Consultation Response from KC Highways Development Management**Date Responded: 06/06/24** | **Responding Officer: R.Kinder** | **Responding Ref: K2-20NW/6**

2022/91477 Land off Lindley moor Road, Lindley.

Updated Comments dated 06-06-2024.

REV	DATE	DESCRIPTION
PROJECT		
LINDLEY MOOR ROAD LINDLEY MOOR		
TITLE		
PROPOSED INTERNAL VEHICLE TRACKING		
SCALE		
1:500 @ A1		
DRAWING		
2061-102		
DATE		
25.04.2022

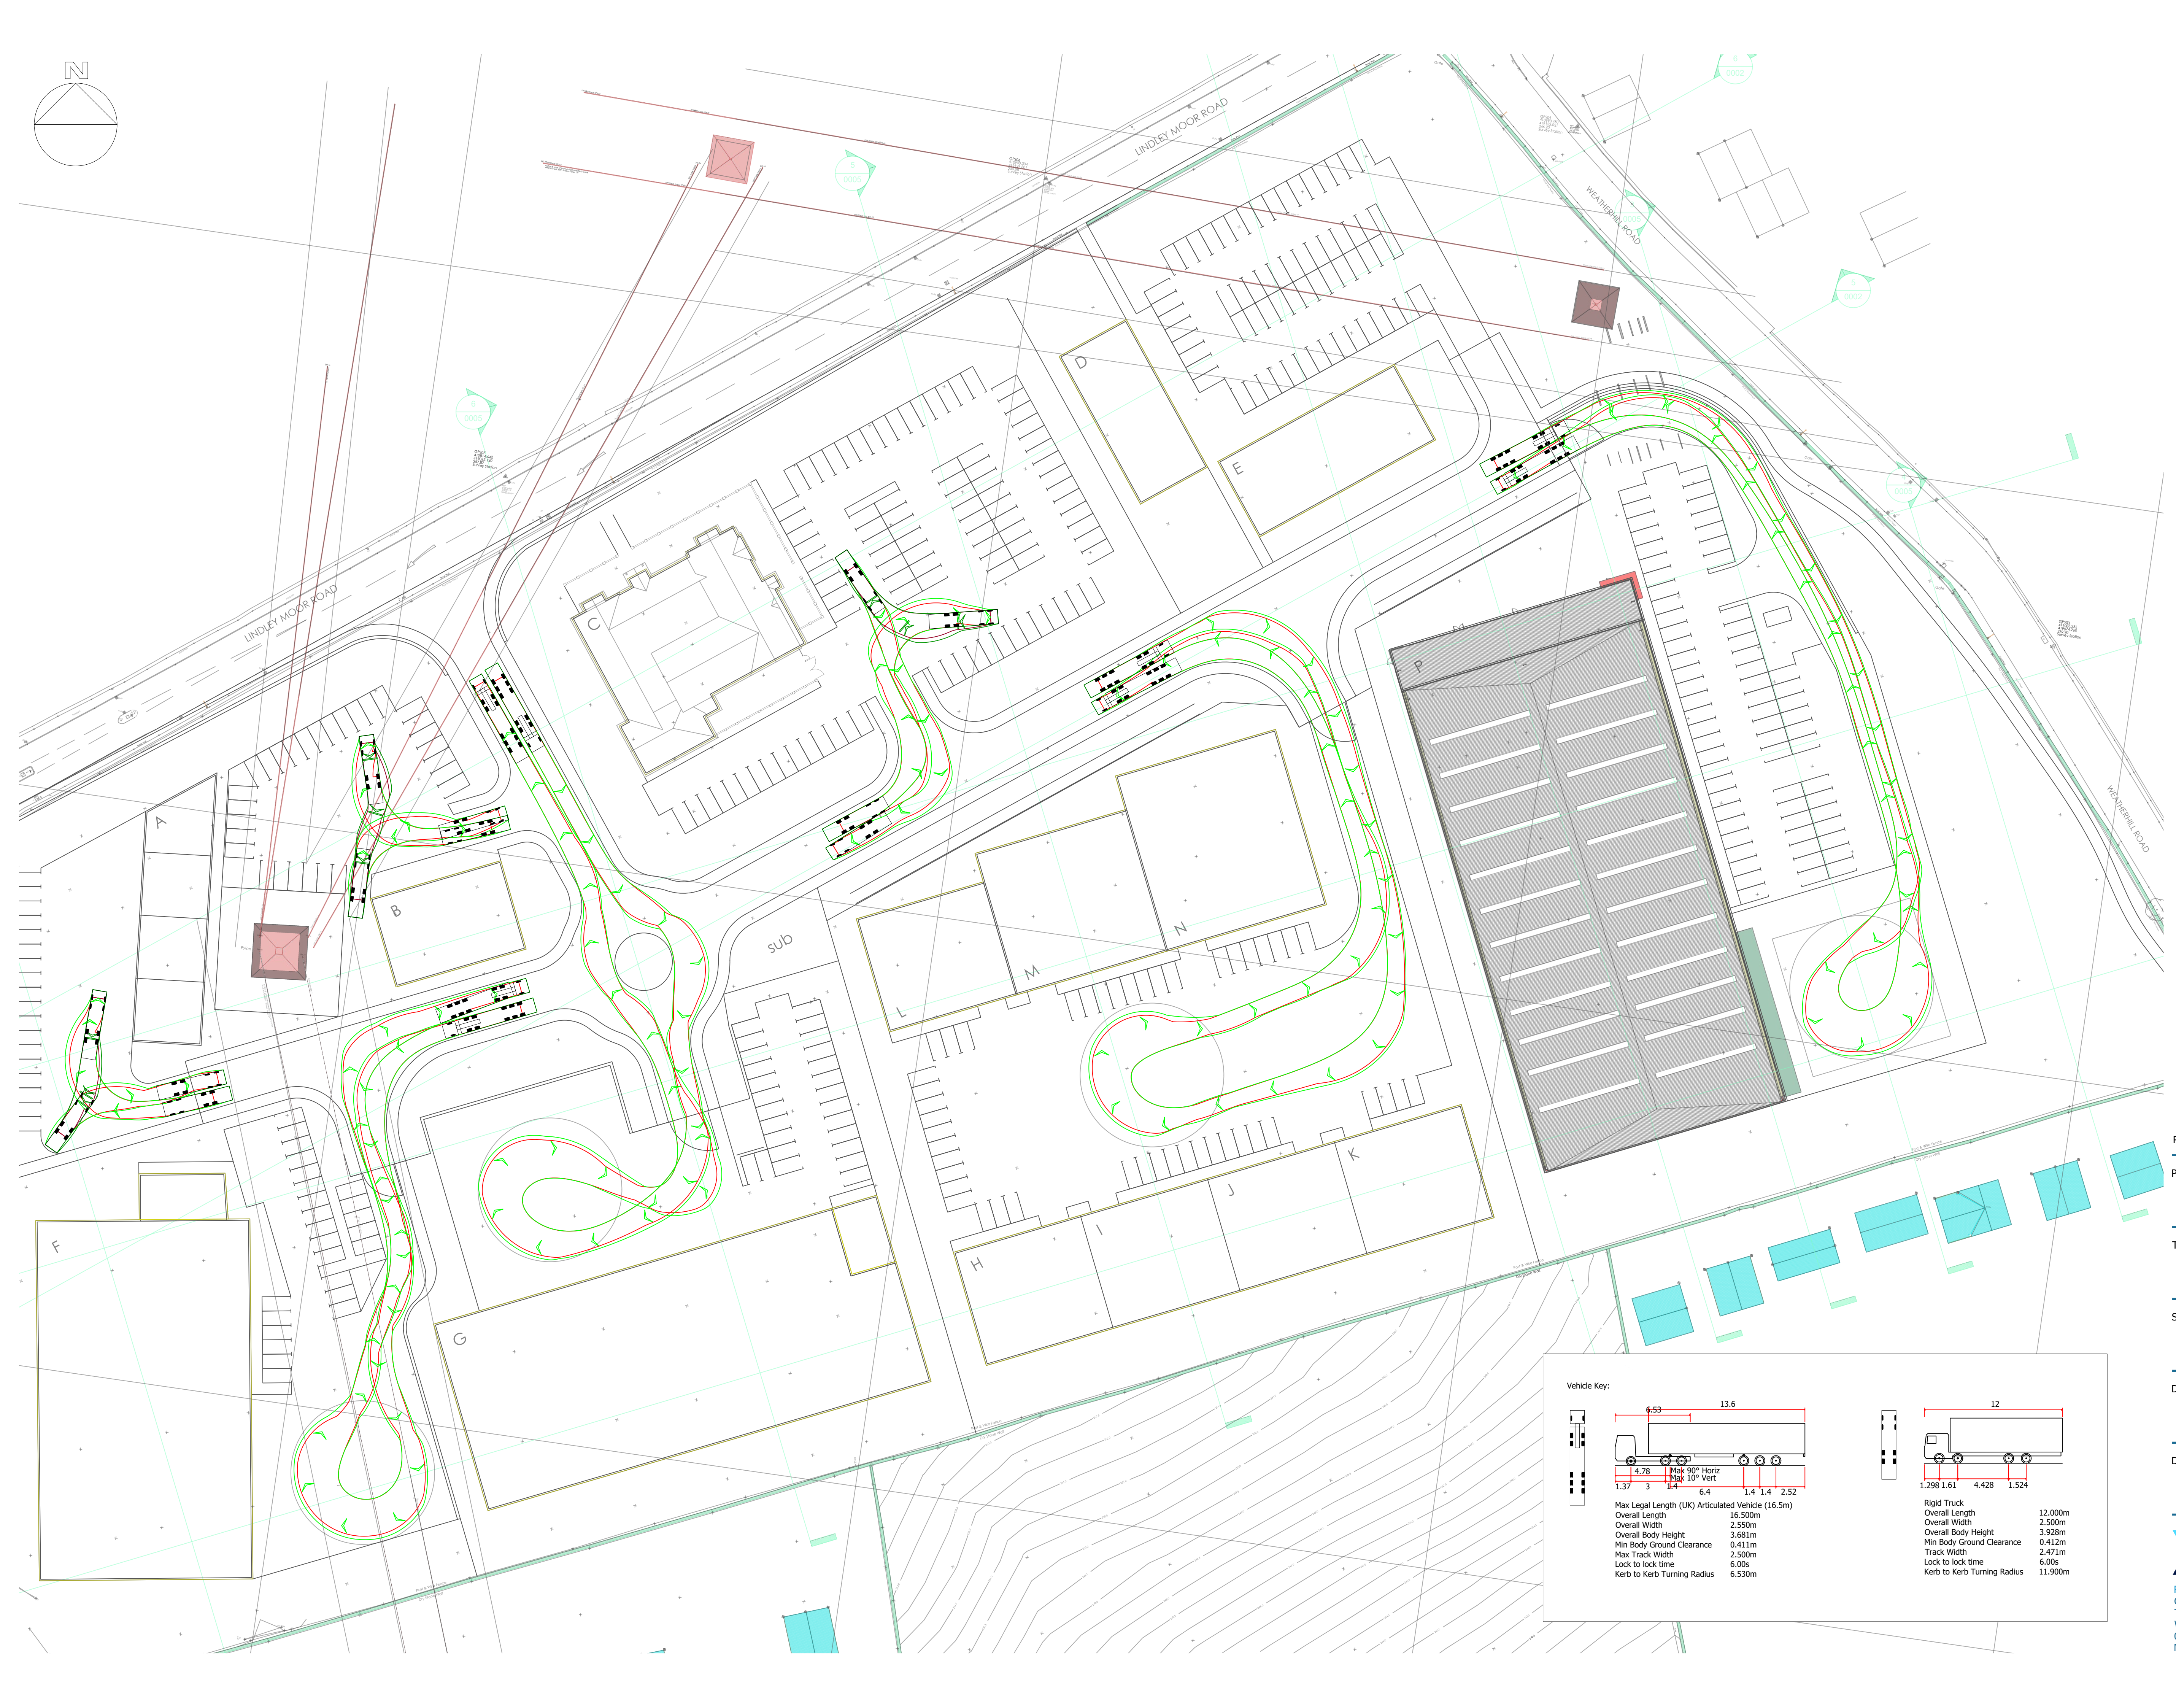
The internal layout should be designed in accordance with the Councils SPD Highway Design Guide for industrial /commercial developments, further information on this can be found in table 2 on page 32 of this document. To summarise in brief the internal should have the following:

- a carriageway width of 7.3m minimum.
- Typical cross section of 2m footway, segregated cycle way, 7.3m carriageway, segregated cycleway and 2m footway.
- 33m forward visibility splays within the adopted highway.
- a balance crossfall either side of the carriageway centreline (cross and long sections required).

The proposed parking provision needs to be carefully considered with the correct provision and sizing of parking bays, enough disabled provision swept paths of vehicles manoeuvring in and out of bays where space appears tight in some instances.

The internal layout has a roundabout proposed and should comply with CD116 Geometric Design of Roundabouts.
